Hu Yu Residence

Addition and Remodel

SHEET NUMBER:
A1.01

Summary of Comments on 2201-224-SUB1-PLANS_review.pdf

SHEET NUMBER:  
**A1.01**

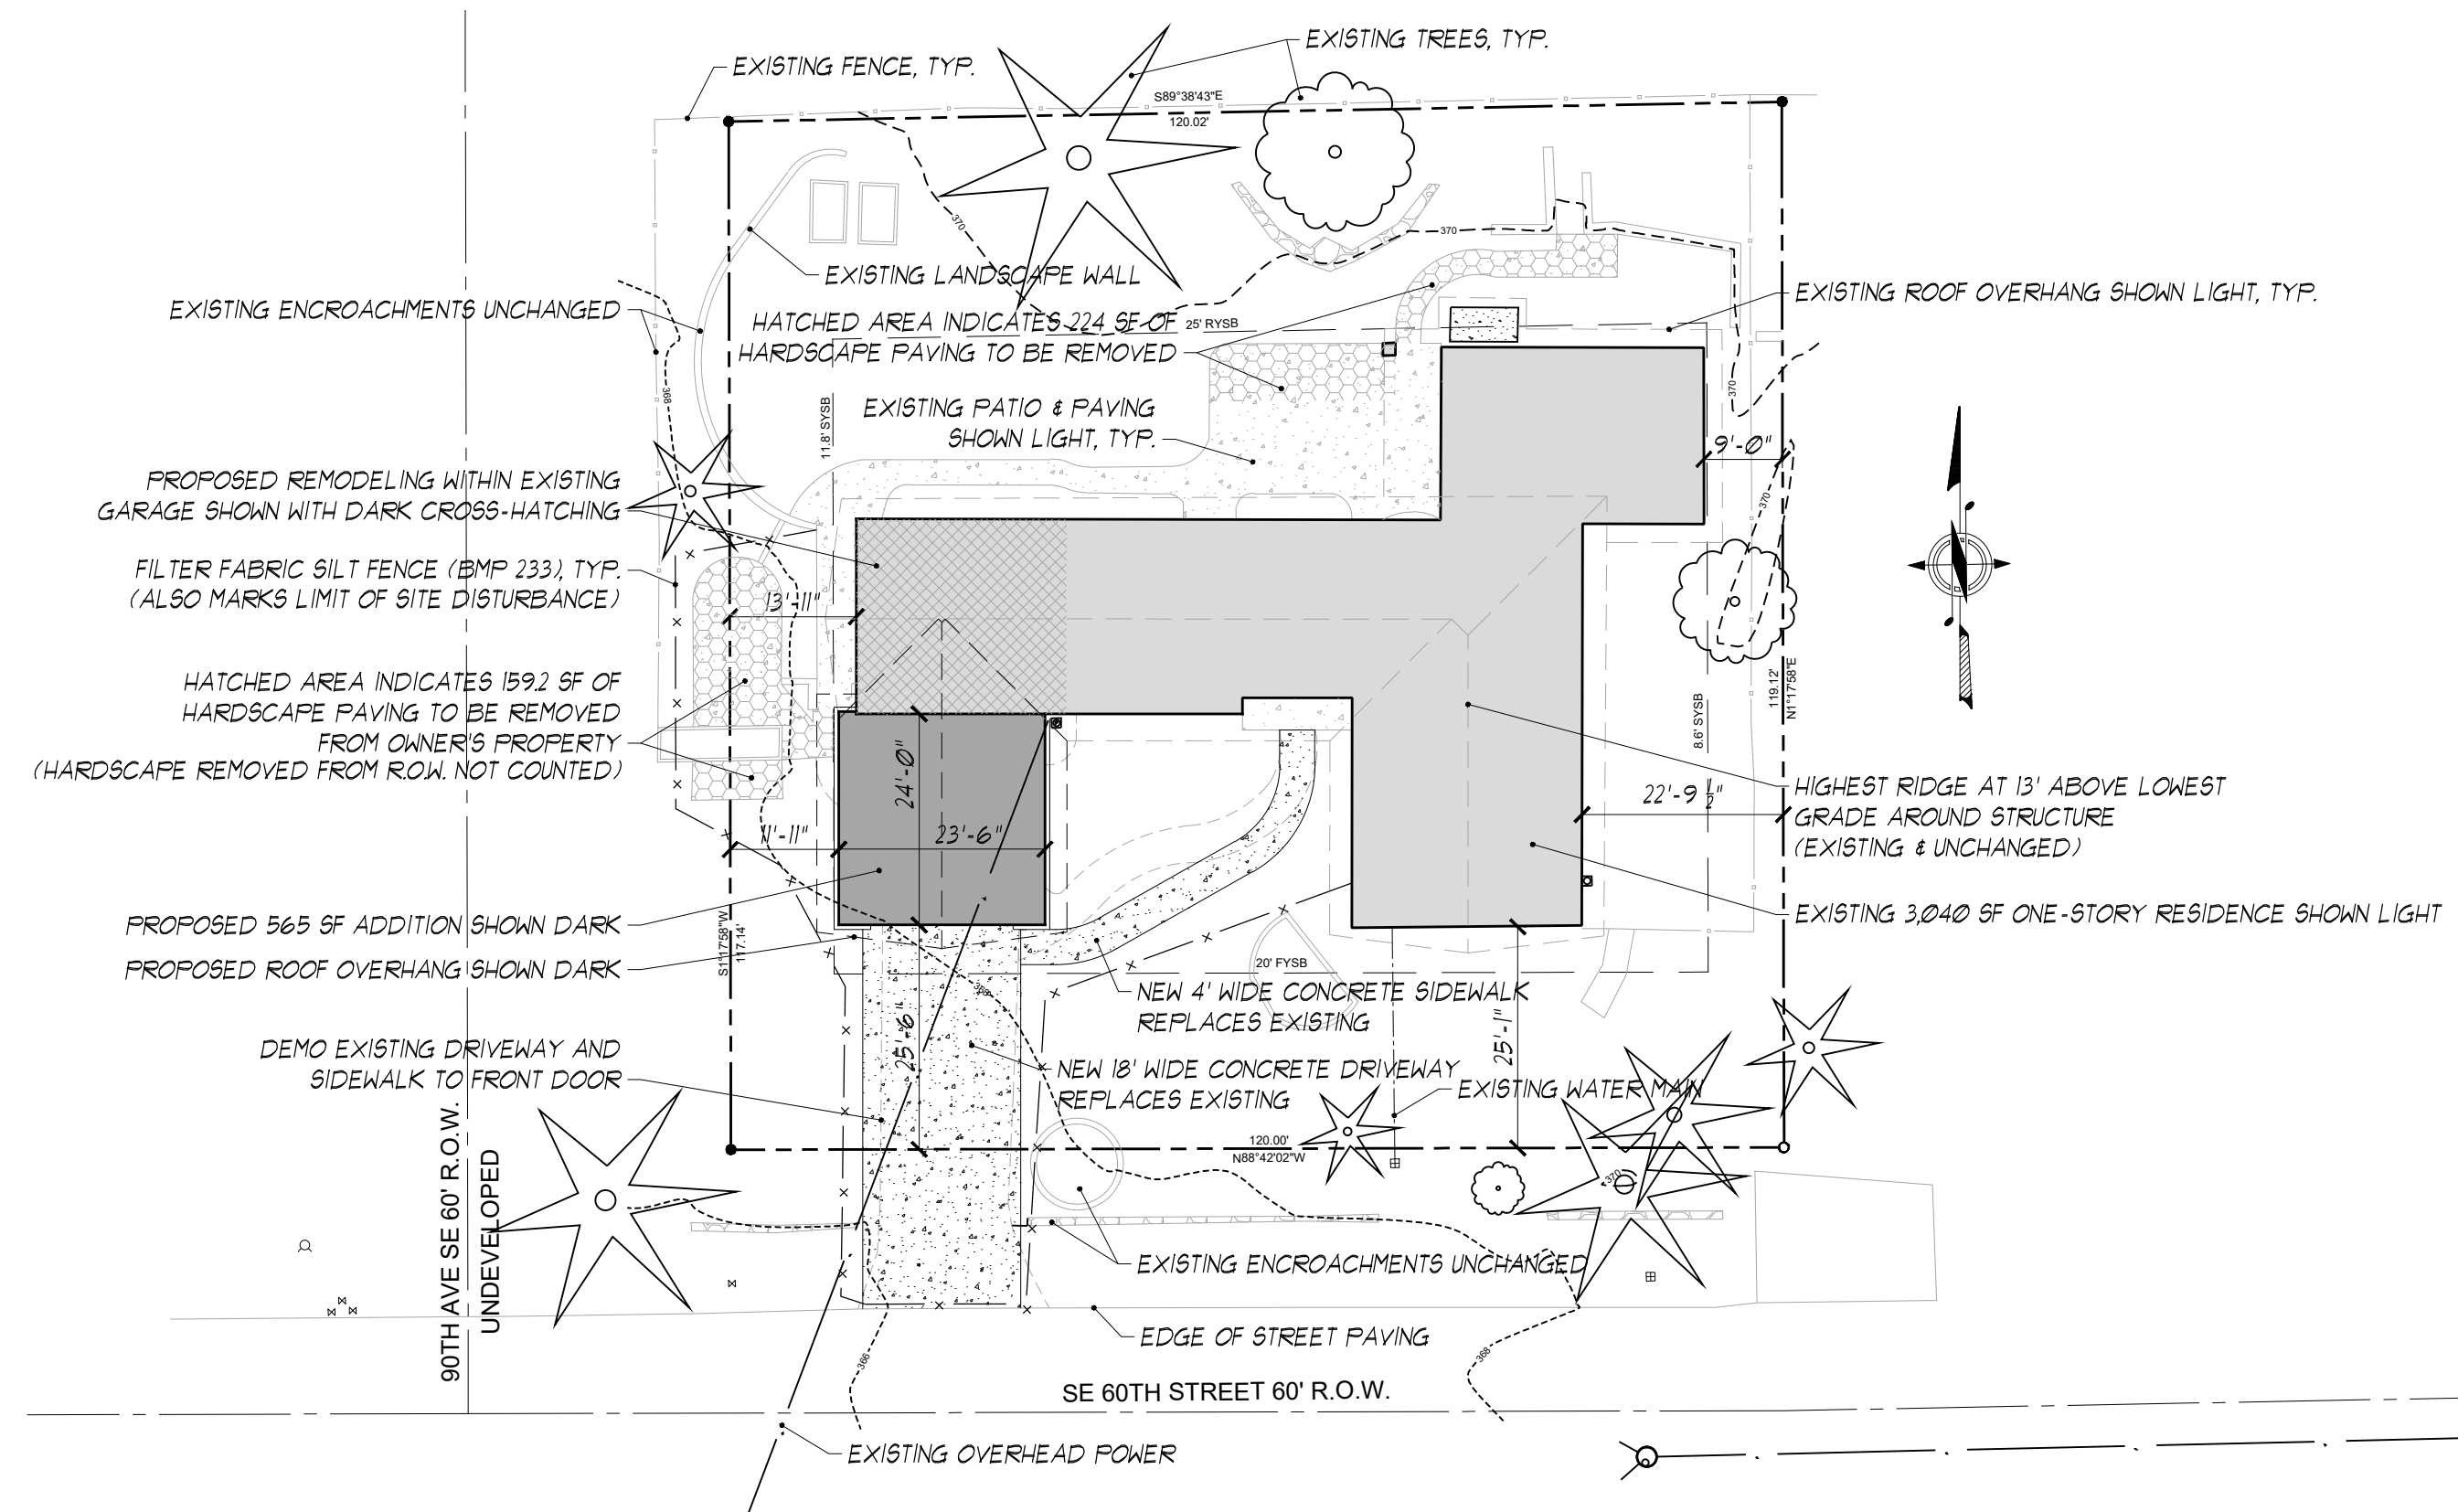
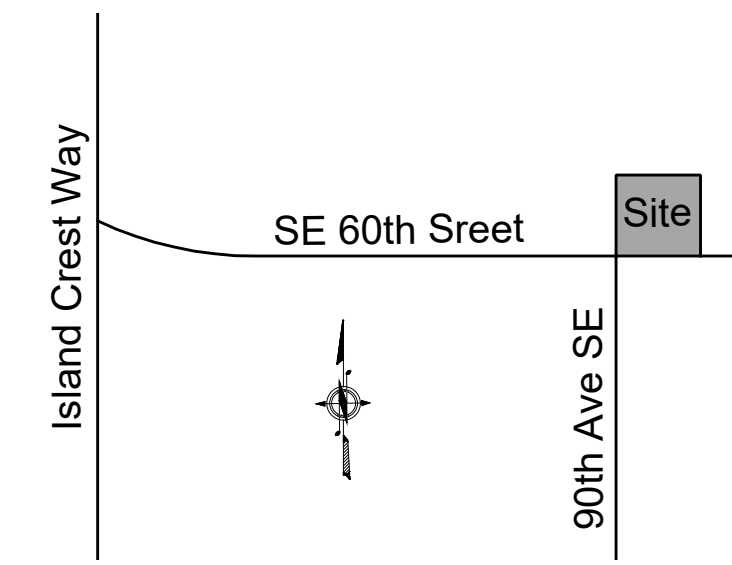
Silt fencing must be installed on private property and may not encroach into City ROW. As shown, silt fencing currently encroaches into ROW on the southern and western fronts.

Number: 2 Author: Land Use Planning Review (molly.mcguire@mercerisland.gov) Subject: Sticky Note Date: 6/6/2022 10:04:24 PM
 No leave encroachment is allowed into minimum side yard setback on interior lot lines. Please show minimum side yard setbacks per MICC 19.02.020(C)(1)

If jogging side yard setbacks, clearly show where jog occurs and show that the sum meets the 17% of lot width requirement. In this case, the minimum side yard setback is 33% of the aggregate side yard setbacks since the variable side yard setbacks do not apply.

Provide additional information to clarify how and where the storm runoff from the driveway will flow to.

1) Identify the construction access. If the existing driveway will be used as access, please note it.

2) Identify stockpile/staging area. Stockpile/staging area must be located on private property.

Number: 5 Author: Tree Review (john.kenney@mercergov.org) Subject: Sticky Note Date: 5/26/2022 9:58:03 AM
 Call out no new gravel in the area near city tree. No silt fence allowed in right of way. But 3' orange fence should be put up in right of way to protect area near this cedar from compaction during construction.

No concrete or pavers in ROW.

Show and provide a note that all storm drain inlets within 50' of the site must have inlet protection. Provide detail for storm drain inlet protection.

Number: 8 Author: Land Use Planning Review (molly.mcguire@mercerisland.gov) Subject: Sticky Note Date: 6/6/2022 10:20:10 PM
 Show lot slope calculation on plans. High and low points and the shortest vertical distance between.

Include table **R402.1.1** from the wsec on the permit plan set.
